WEST SUSSEX COUNTY COUNCIL CONSULTATION

TO:	Arun District Council FAO: Amber Willard
FROM:	WSCC - Highways Authority
DATE:	9 May 2022
LOCATION:	Boundary wall to Nyton House, Nyton Road, Westergate, PO20 3UL
SUBJECT:	AL/56/22/PL Part demolition of boundary wall to form new access to existing site (resubmission following AL/10/22/PL). this application affects the setting of a listed building and is in CIL Zone 3 (Zero Rated) as other development.
DATE OF SITE VISIT:	n/a
RECOMMENDATION:	Advice
S106 CONTRIBUTION TOTAL:	n/a

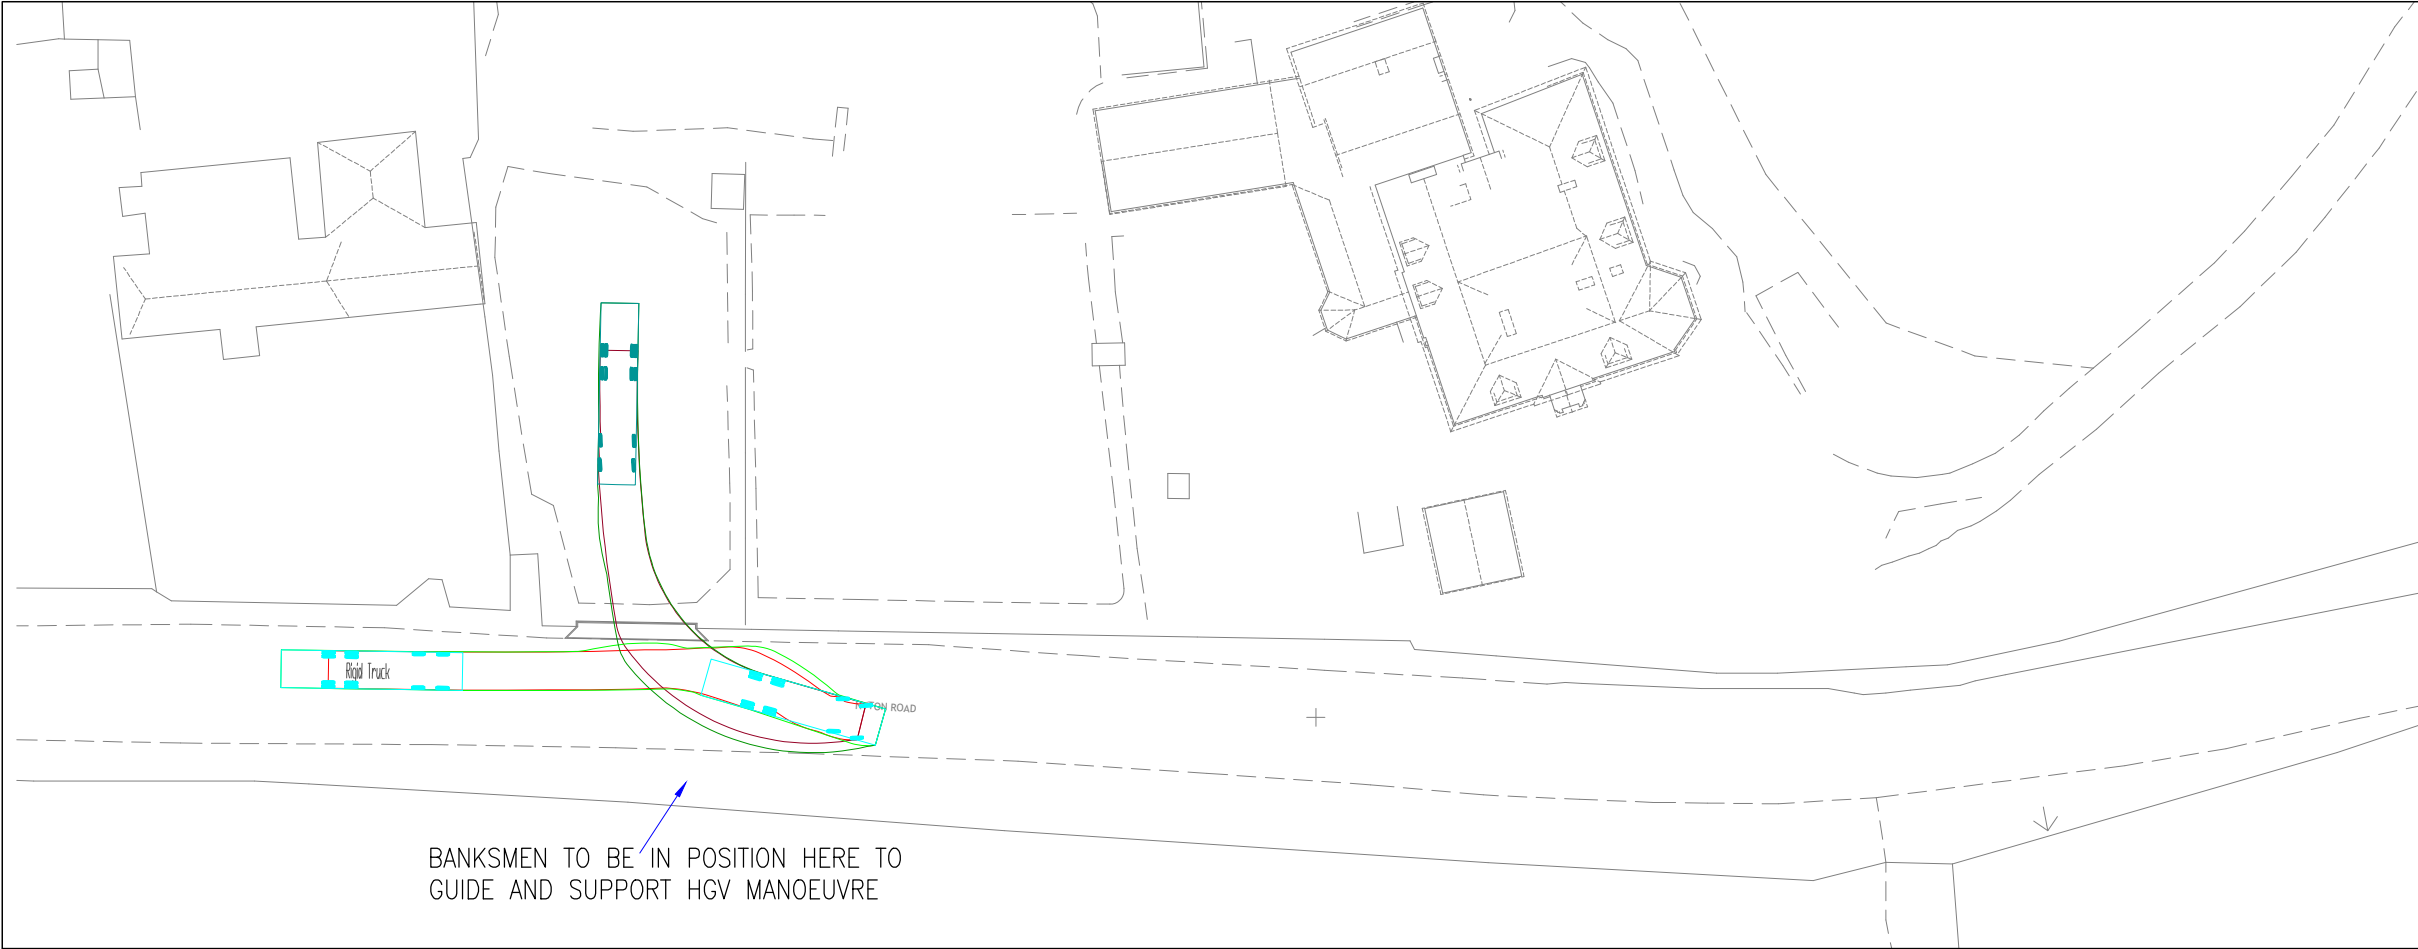
The supporting information also includes vehicle tracking to demonstrate how the geometry of the access is suitable for a 16.5m articulated vehicle and 12m rigid body vehicle. These are considered acceptable.

Site Plan
showing visibility splay

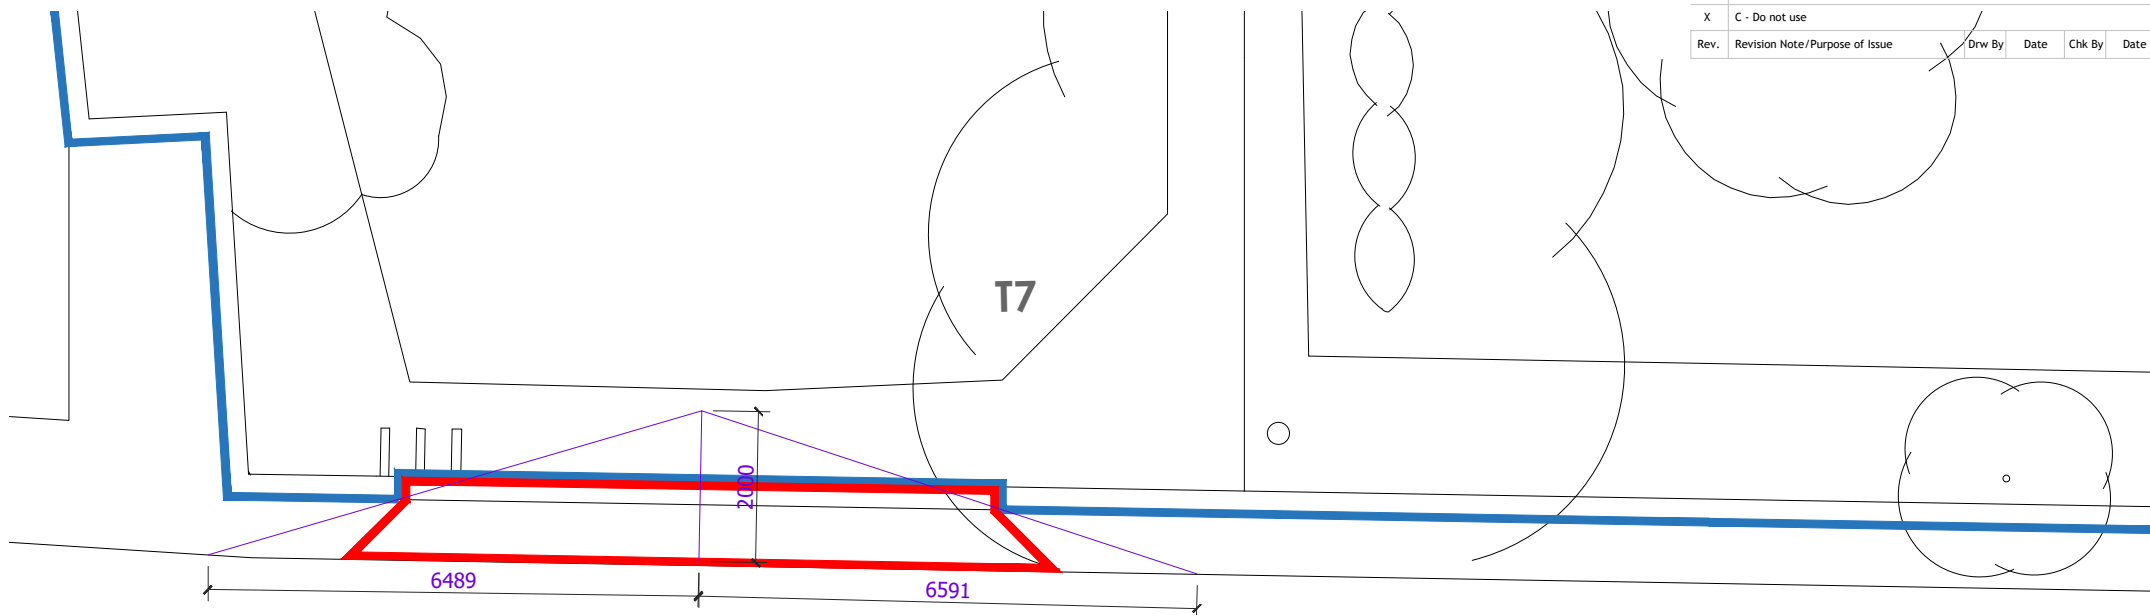
The submitted plans details that the access will be afforded visibility splays of 2.0 x circa 6.5 metres. Nyton Road at this point is subject to a 30-mph speed limit, though given the nature of the road it is not unreasonable to consider that actual road speeds may be above the posted speed limit.

Given the limitations with visibility at the access point, if consent is to be granted, the Local Highways Authority would request the Local Planning Authority consider applying a suitably worded condition whereby the access point can only be used in order to facilitate construction traffic associated with the implementation of AL/42/19/PL, and be used in accordance with the approved details as secured by Condition 3 (Construction Methods Statement) of AL/42/19/PL.
